Roadway Plans_V1.pdf Markup Summary

CLEARWAY FILING NO. 2, LOT 5

CONSTRUCTION PLANS

CLEARWAY, LOT 5	
OUTLET STURCTURE POND 1 DETAILS	
PROJECT NO. 44-042A	DATE: 09-09-2022
DESIGNED BY: DLM	HORIZONTAL: 1"=50'
DRAWN BY: CLP	VERTICAL: 1"=5'
CHECKED BY: DLM	SHEET 15 OF 16
BMP02

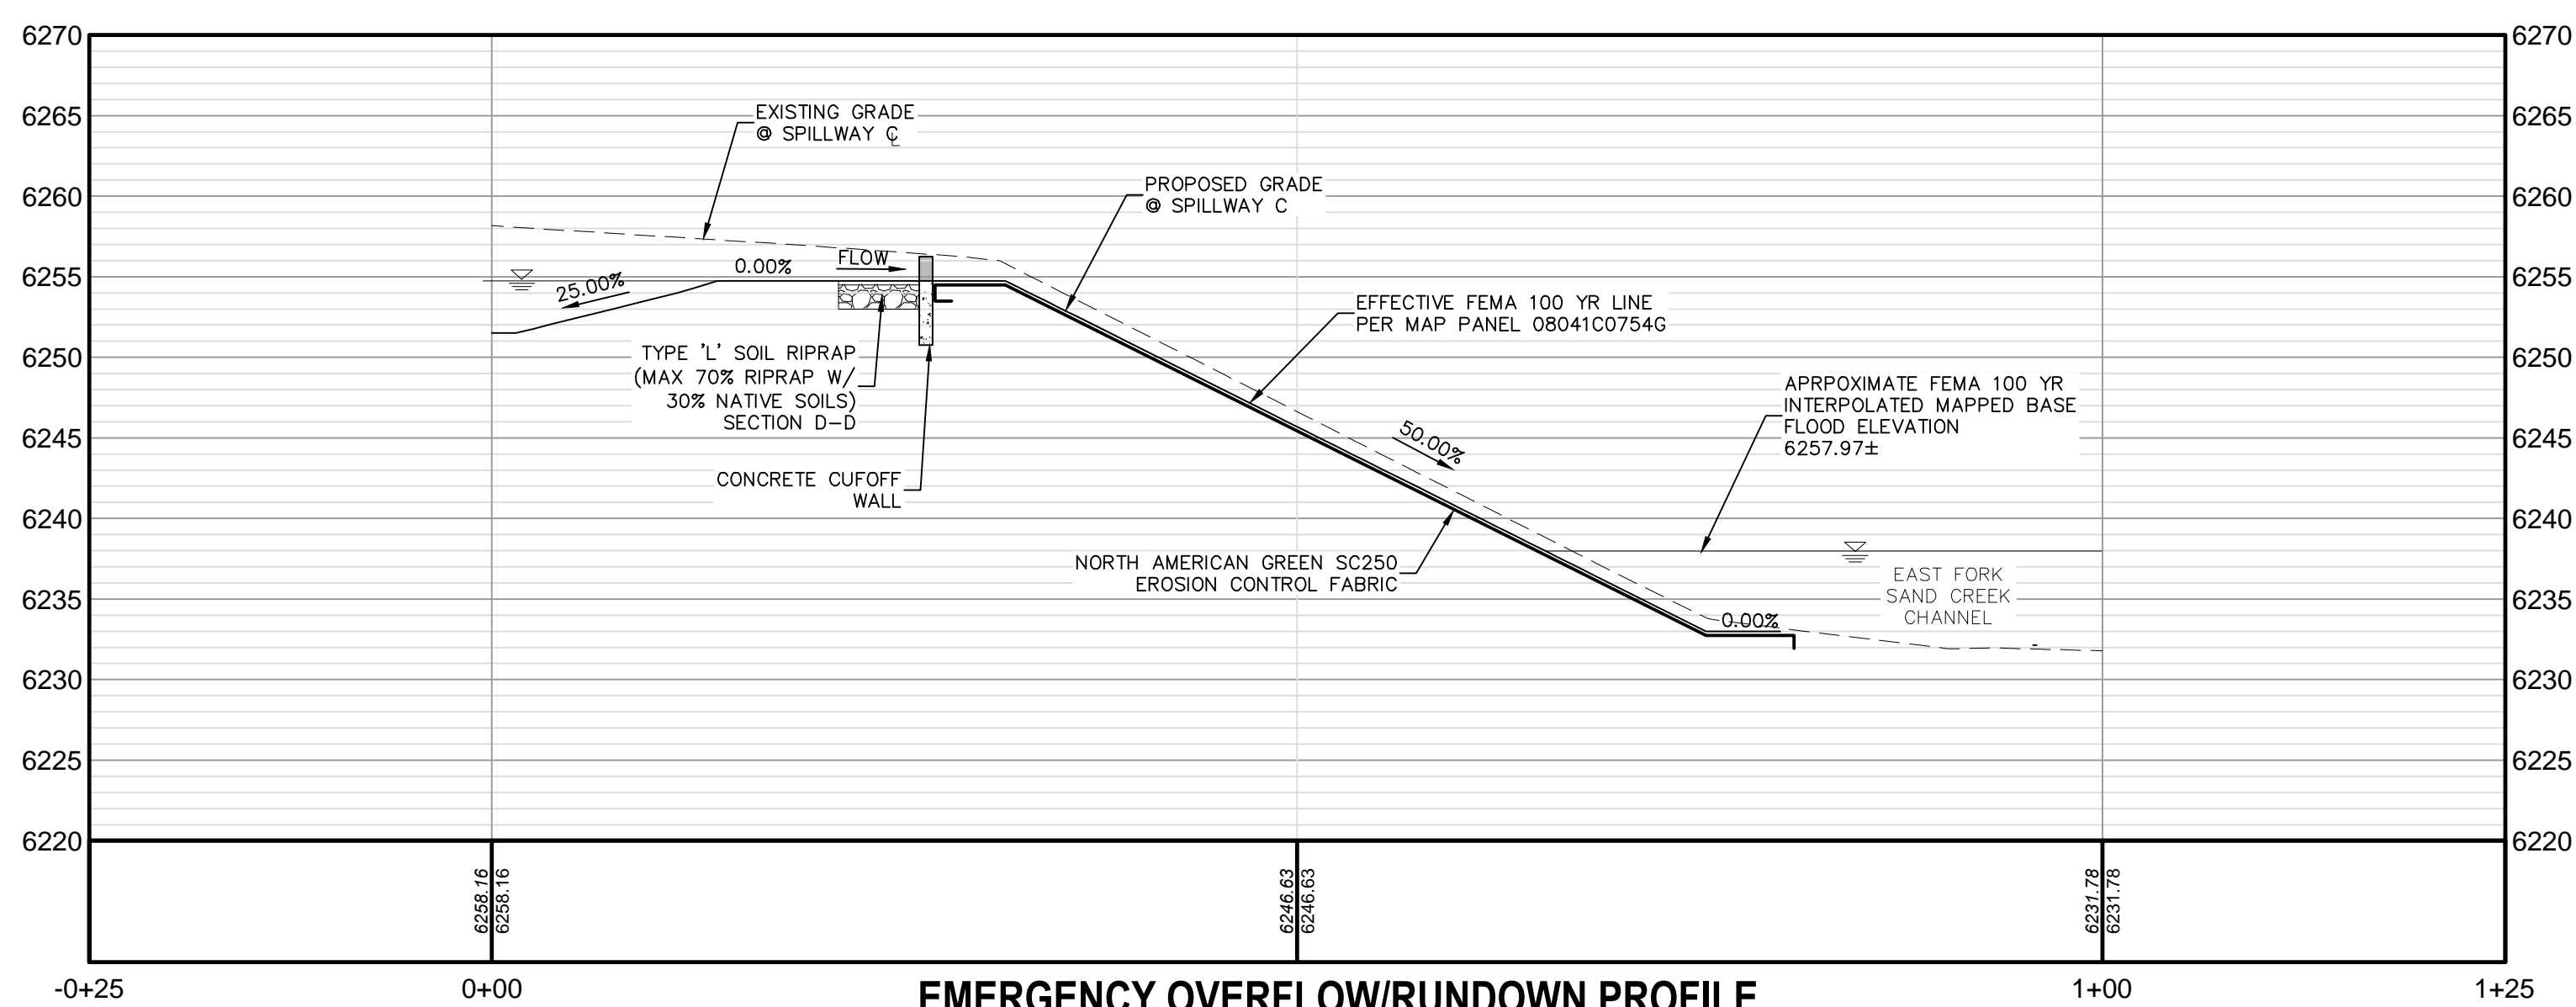
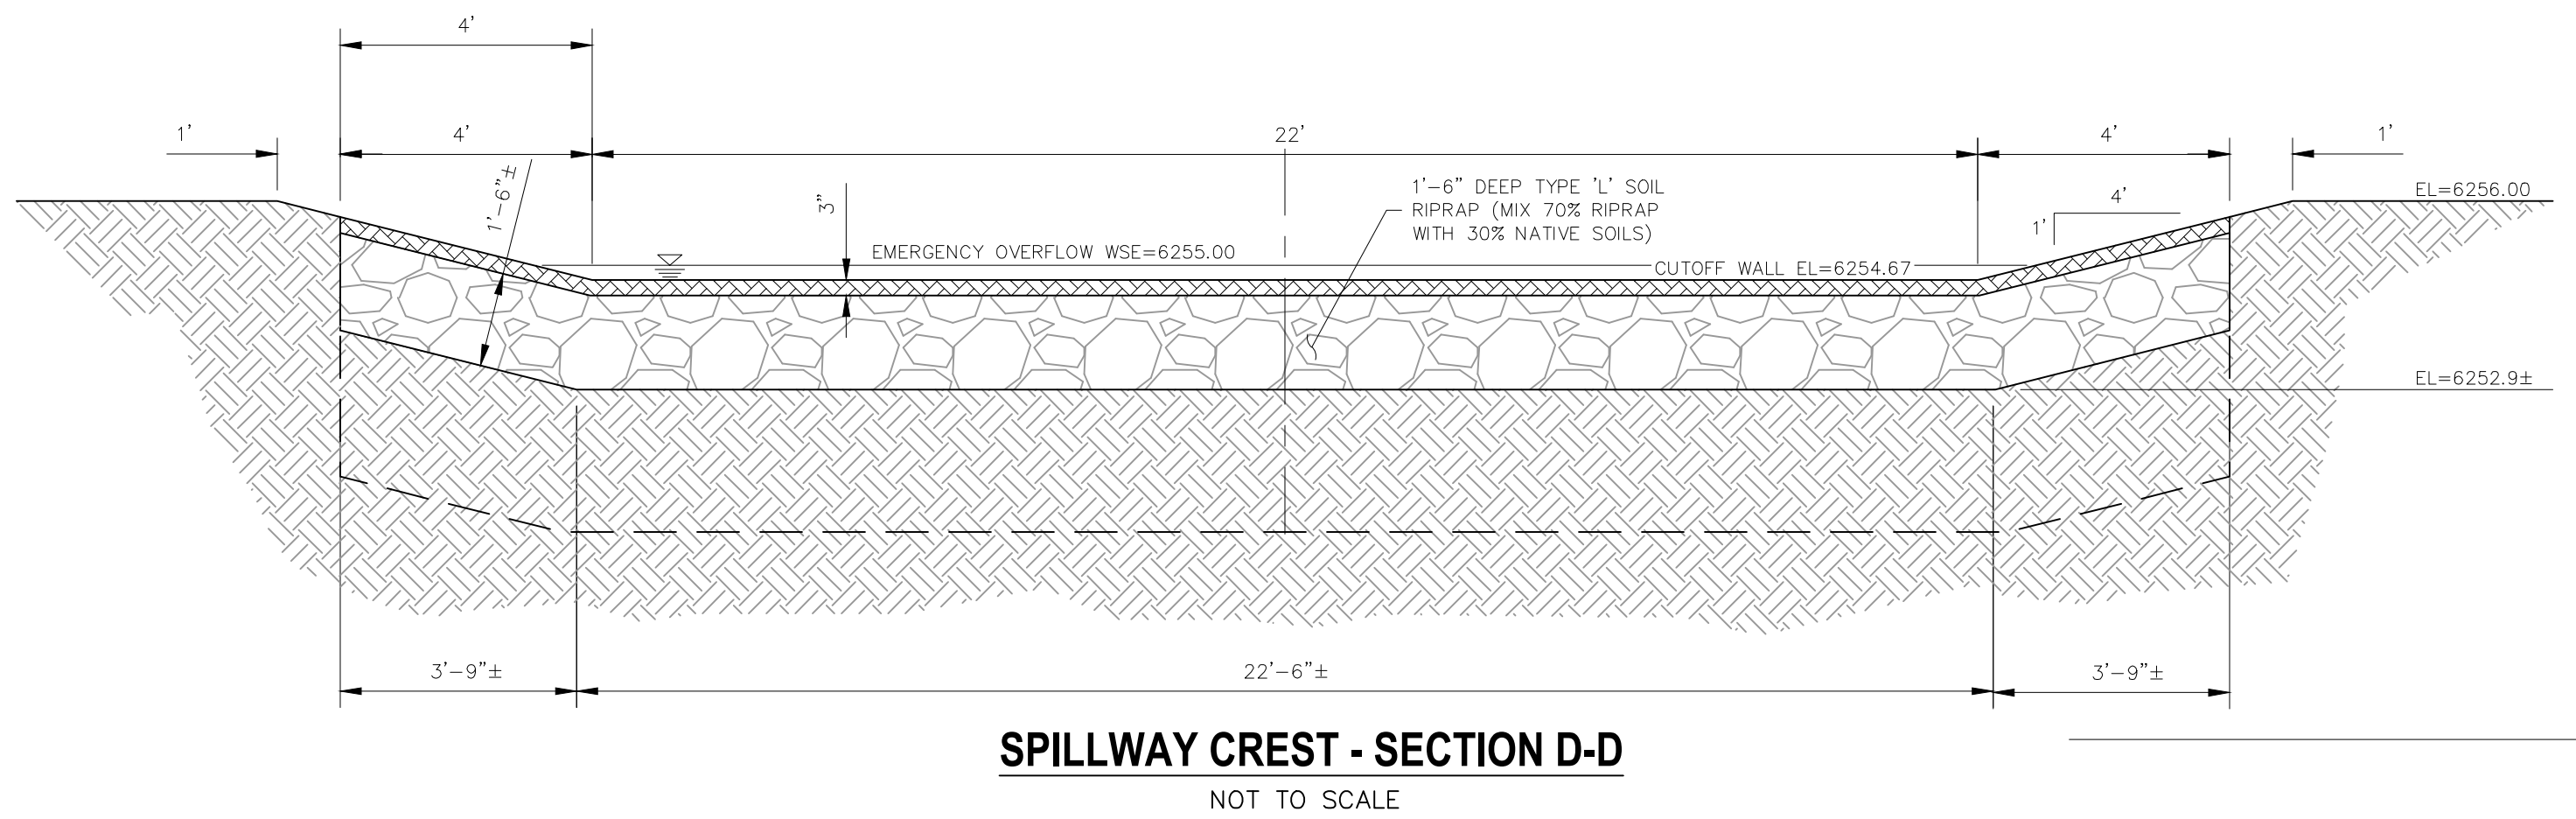
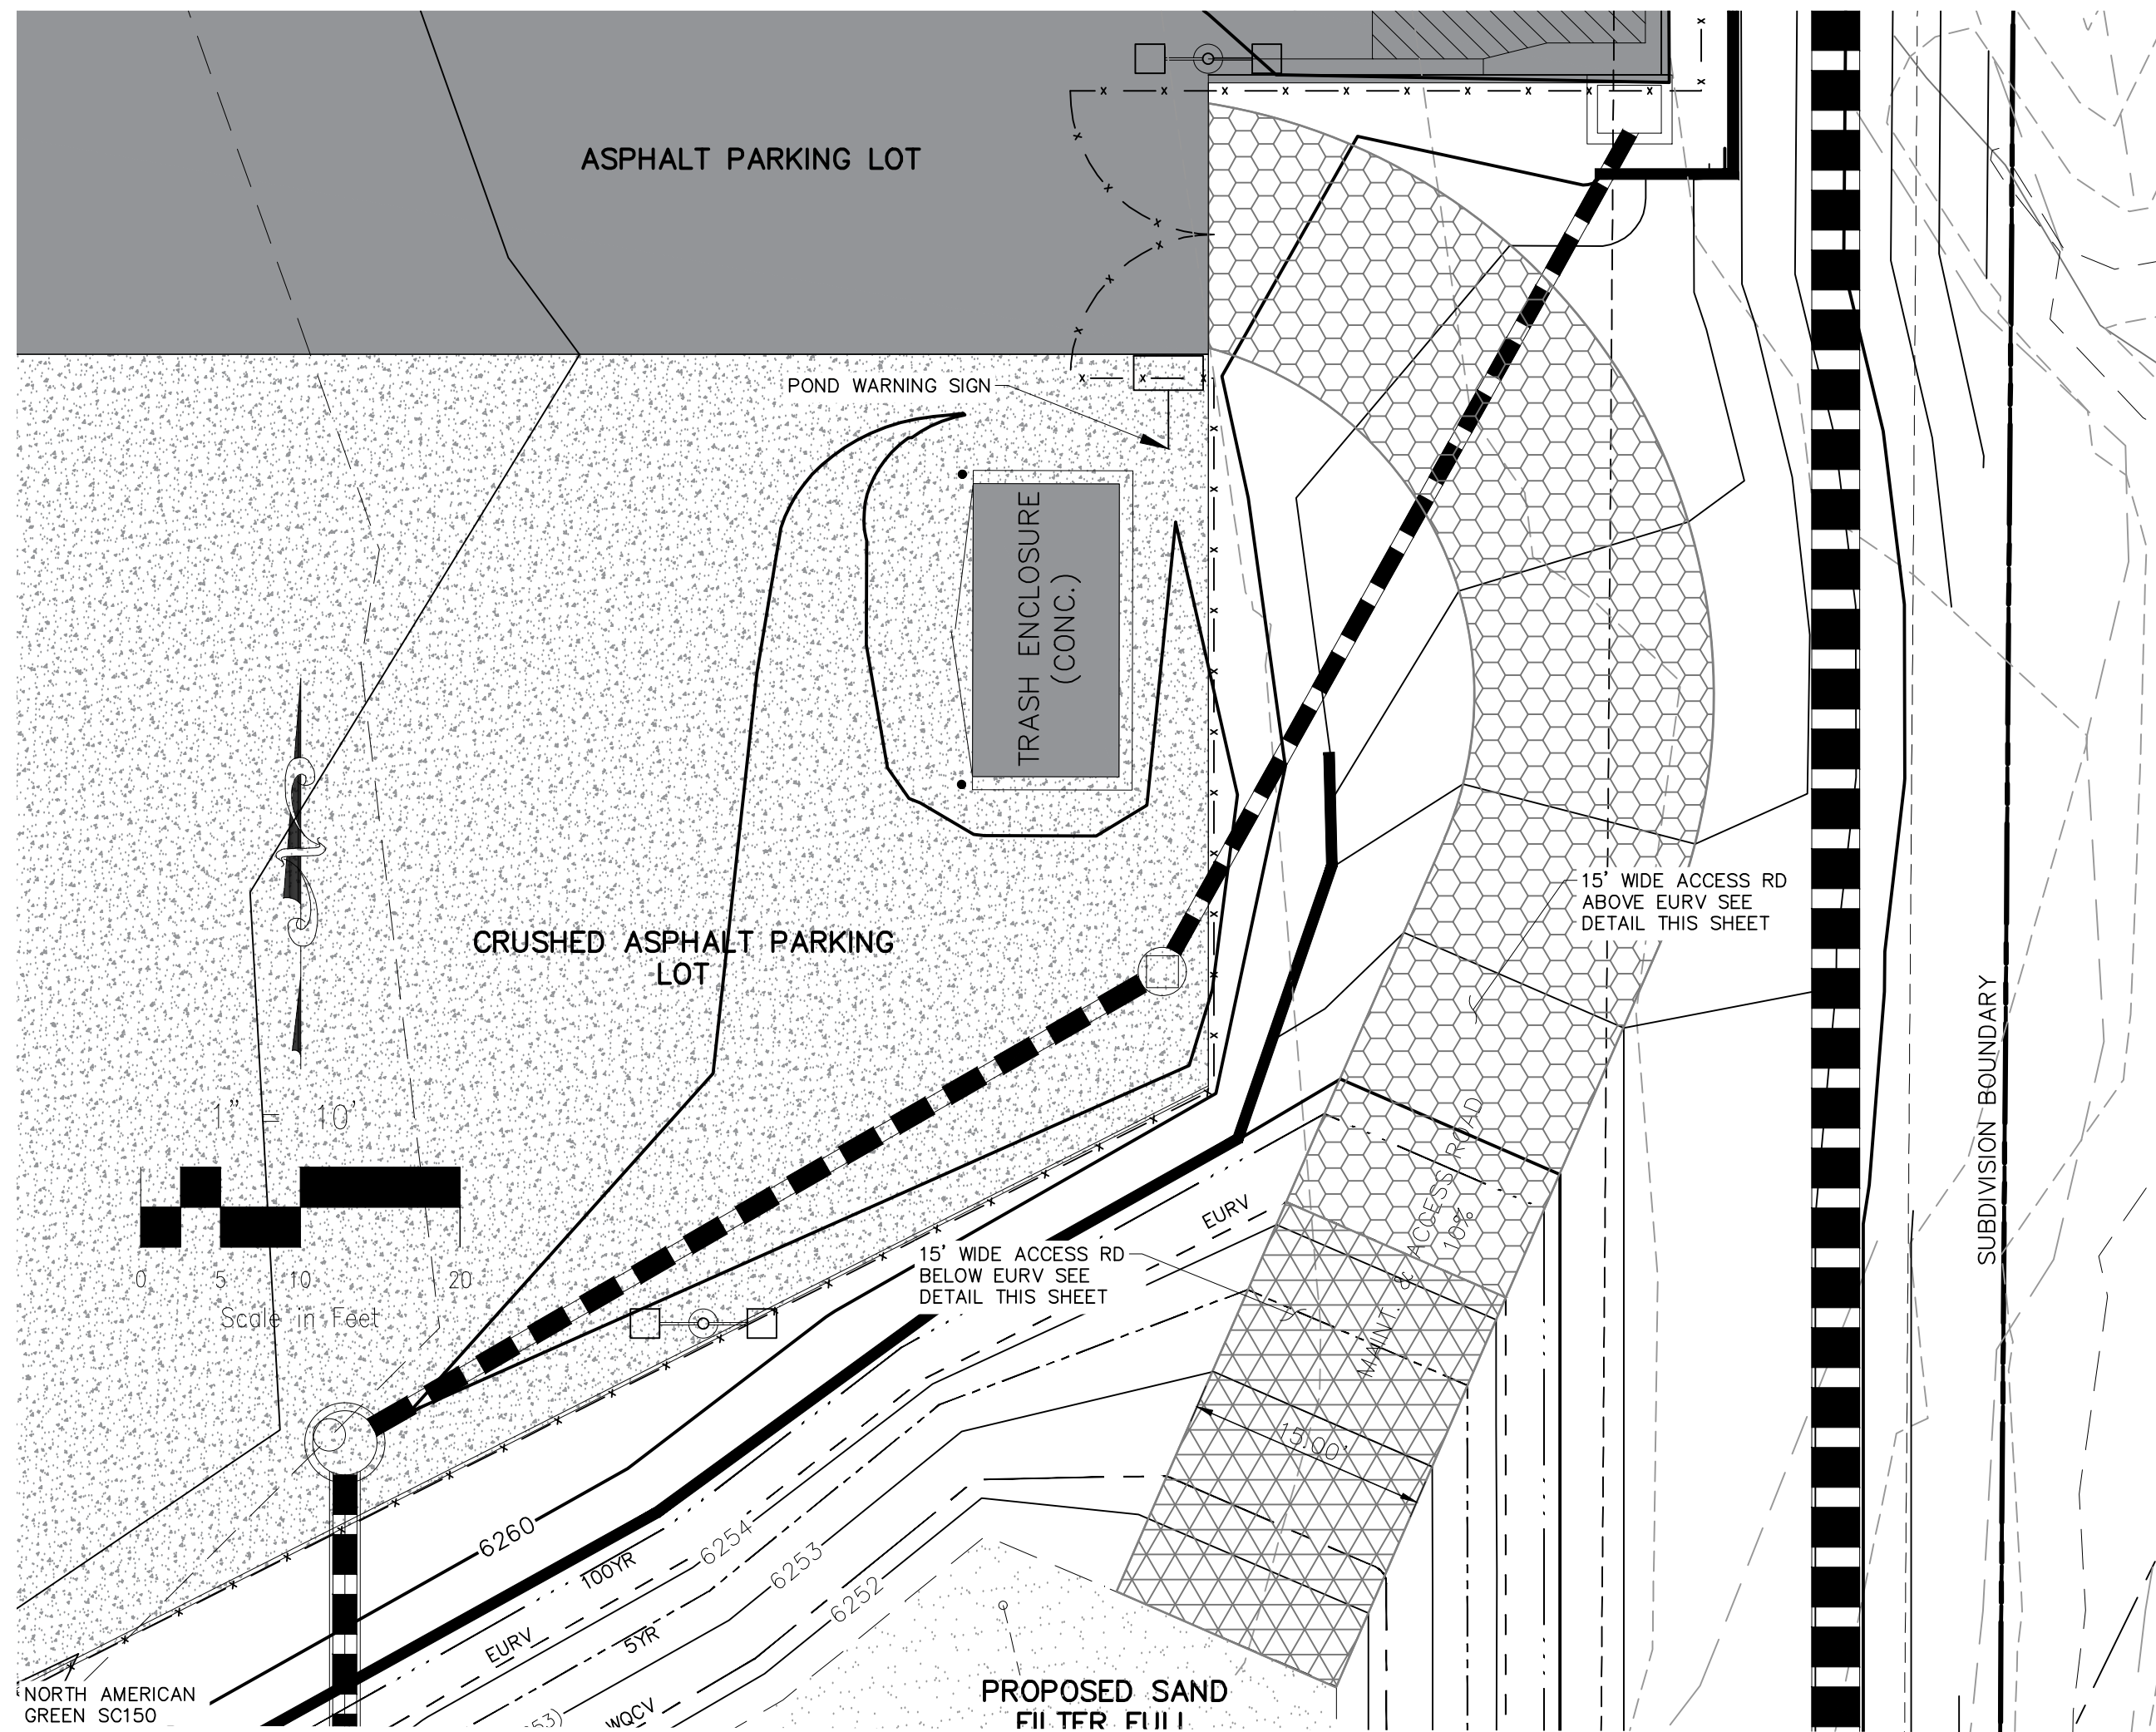
tie all proposed contours to existing

the drainage report indicates that the spillway is designed for 12.8 cfs (rational flow). Revise accordingly.

revise/clarify all section labels

Provide riprap gradation table and note that CDOT Section 506 Requirements apply.

revise callout

adjust overlapping text

include dimensions on plans

MAINT AND ACCESS ROADWAY PLAN

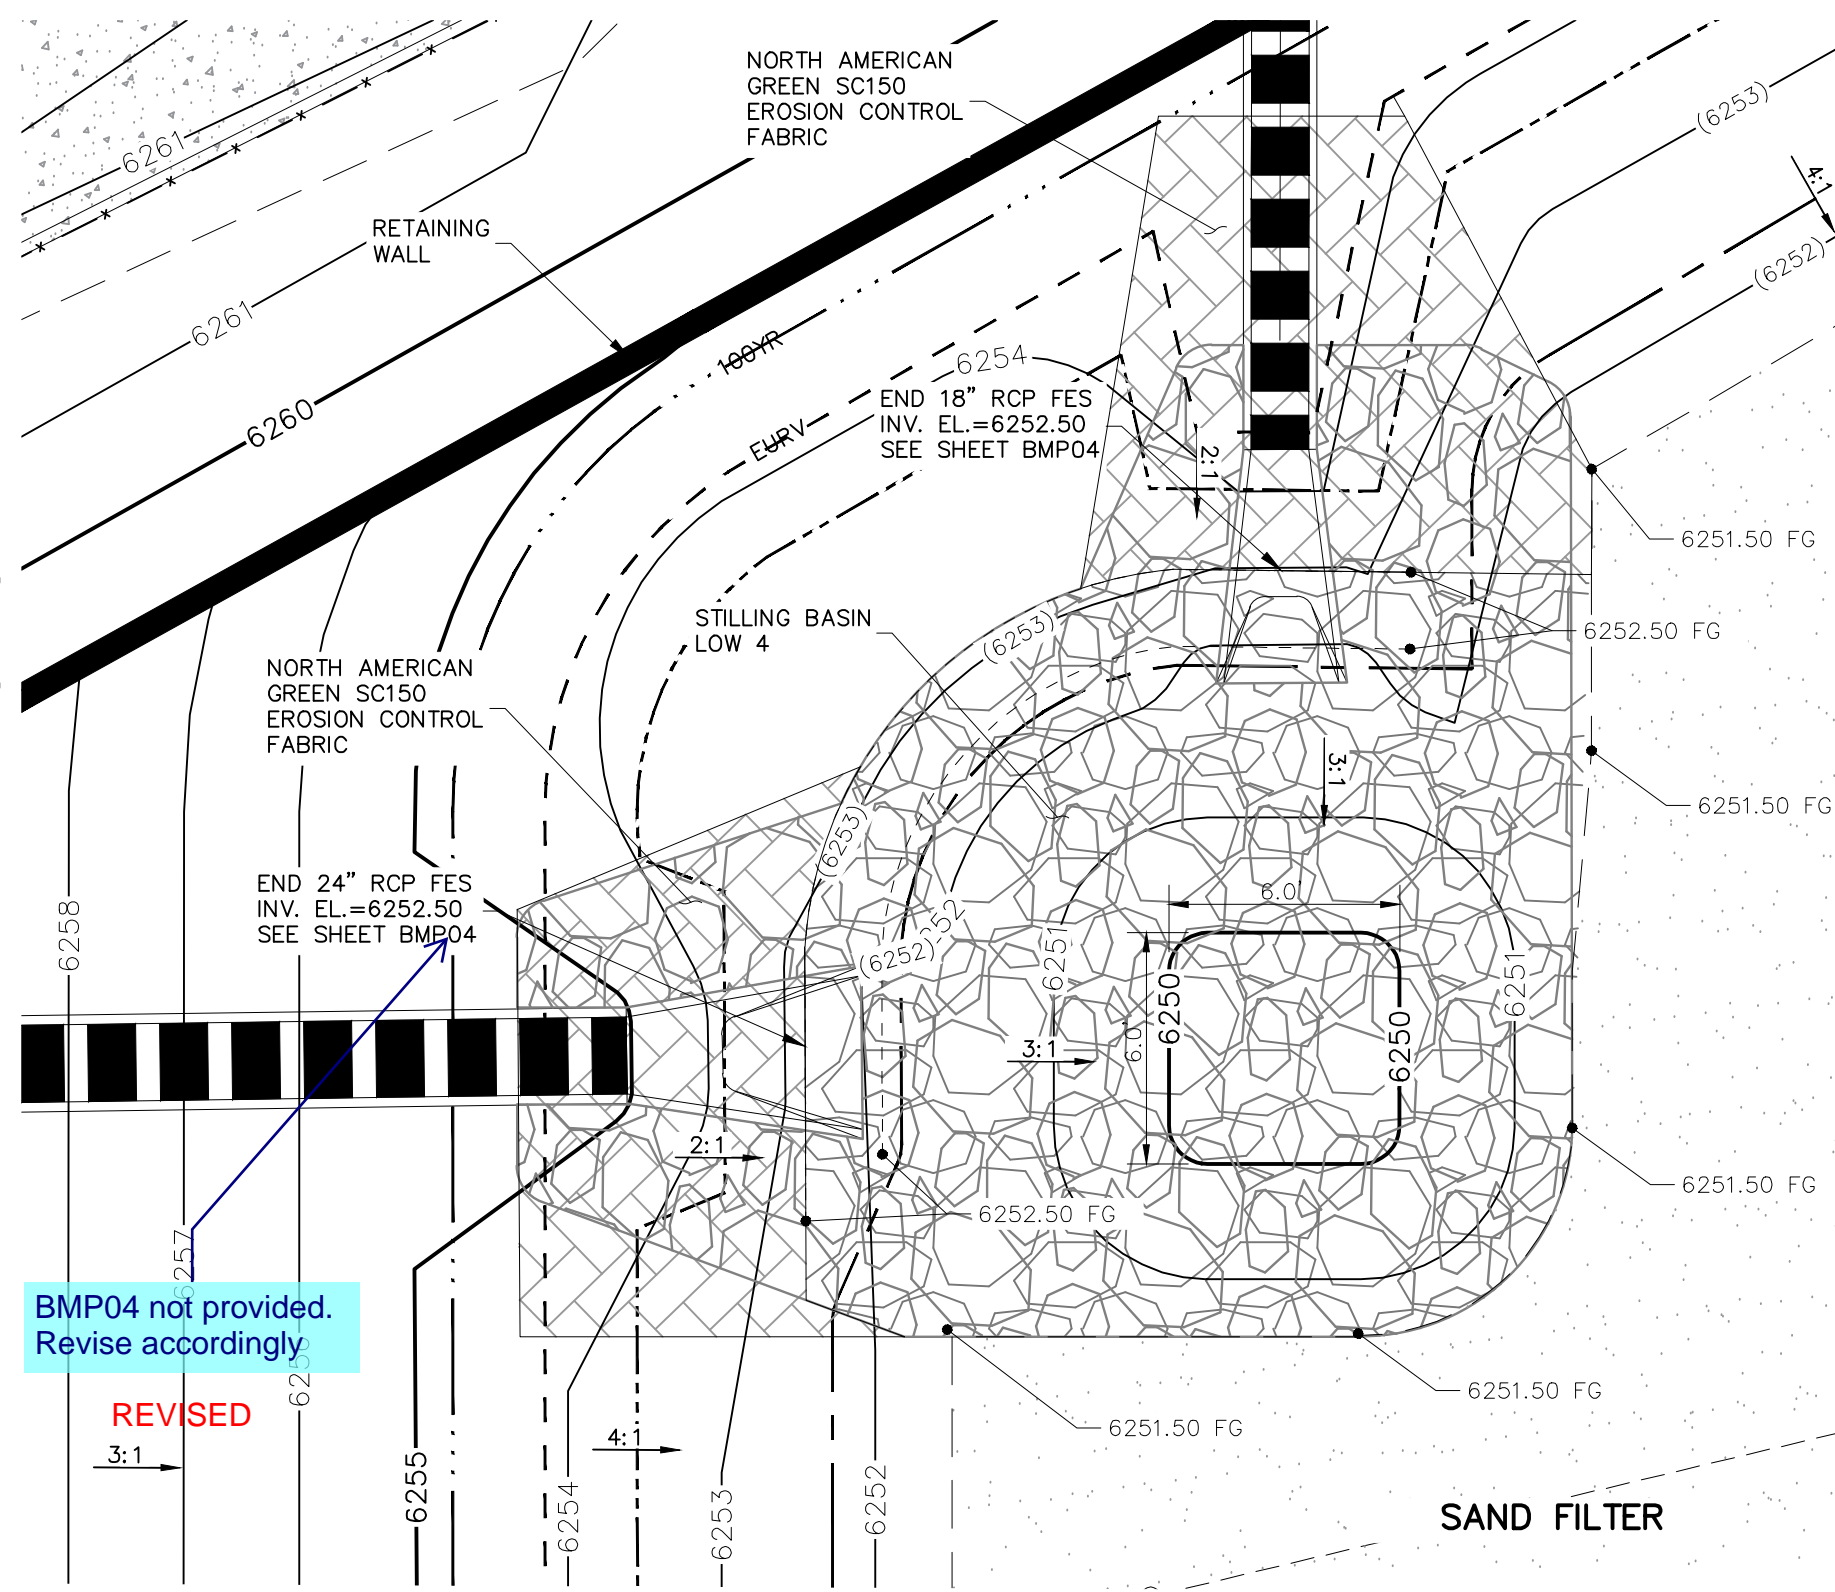
provide sizing calculations in drainage report and show dimensions on plans

Stabilized access ramp shall be a minimum of 15ft wide and no greater than 12% slope, in accordance with DCMv1, Chap 11.2.2. --Unless the anticipated maintenance vehicles and equipment can safely access the pond at specified road width. Properly document this in the Pond O&M manual.
